From: Robert Findlay
Sent: 09 September 2010 11:23
To: Planning.Responses
Subject: FW: Planning Consultation on: BR/244/10/

APPLICATION NO: BR/244/10/

Registered: 01-SEP-10
Site Address: 36-38 Sudley Road Bognor Regis PO21 1ER

Description of Works: Proposed single storey extension.

Proposed Ground Floor
Scale 1:100

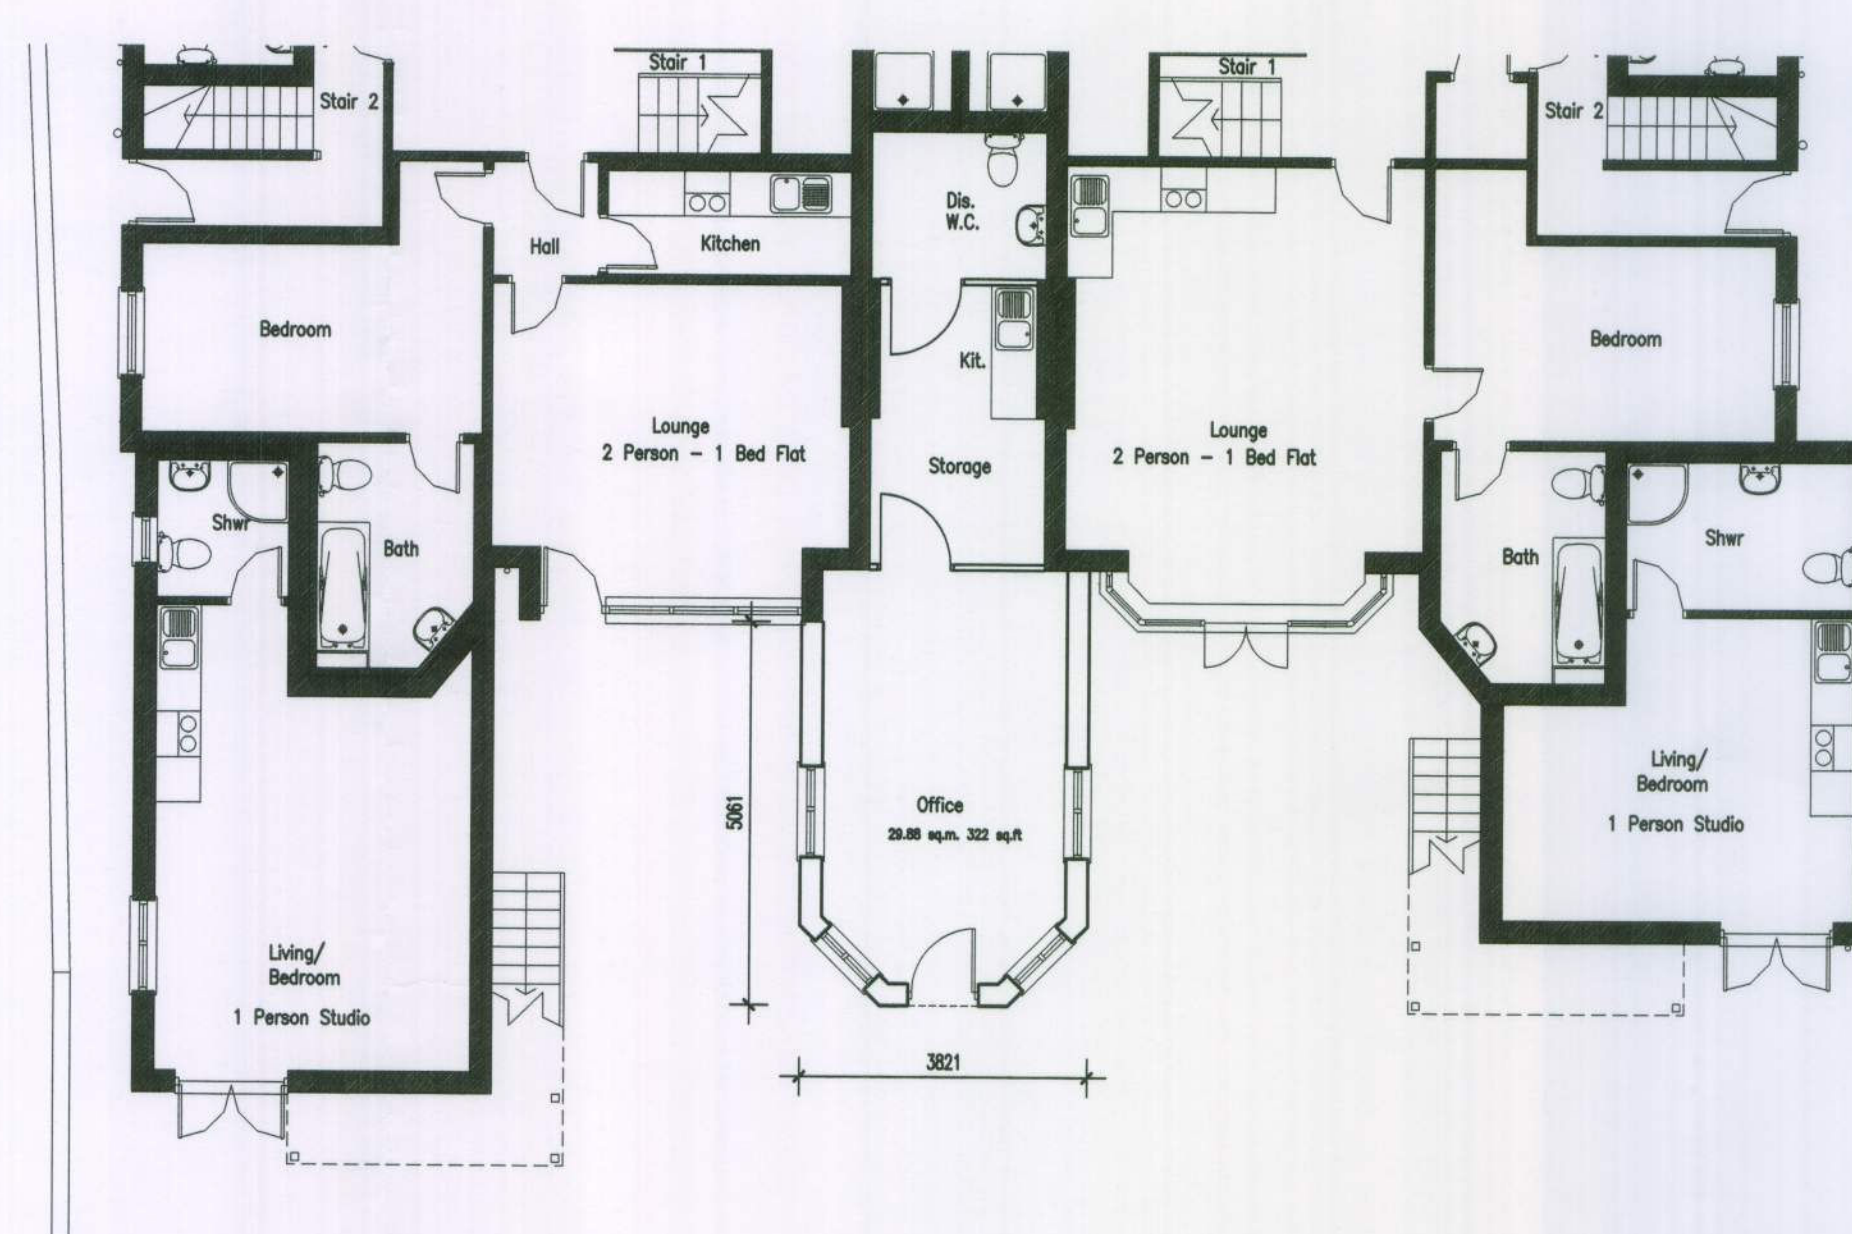
If the accommodation is to be used solely for office accommodation and storage then the kitchen and toilet areas are to be adequately lit and ventilated.

However, with the facilities provided as shown on the drawings it is feasible that the development could be used as residential accommodation and if so the following comments are offered.

There is inadequate natural lighting and ventilation to the kitchen area:

- a. there should be natural lighting provided by glazed windows with an area equivalent to 1/10th of the floor area.
- b. there should be natural ventilation provided by means of openable windows where the area of the openable parts is equivalent to 1/20th of the floor area.
